LUTON AIRPORT EXPANSION PROPOSAL

Reference NUMBER LUTN-028

The comments below refer to the Environmental Statement Non-Technical Survey

Figure C1: London Luton Airport noise monitoring stations and radar tracks, 2019

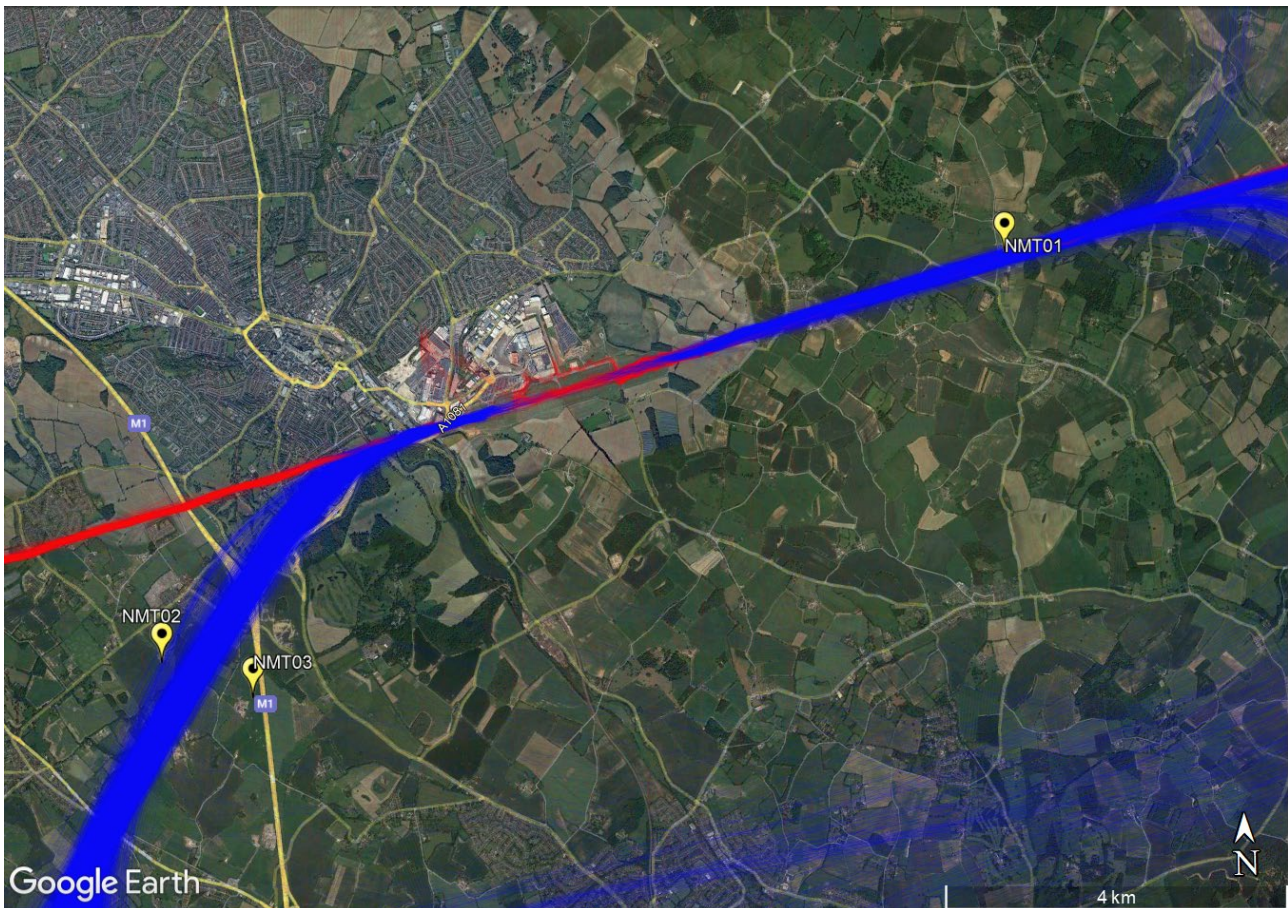
Inset 16.1. This map does not represent accurately all the areas affected by aircraft noise from planes leaving Luton. Many planes pass over our area which is Marshallswick, to the east of St. Albans.

16.1.1 To my knowledge, noise monitoring equipment has not been placed on my area. At peak time aircraft depart from Luton every 2 minutes and can come over my area meaning that conversations have to be halted.
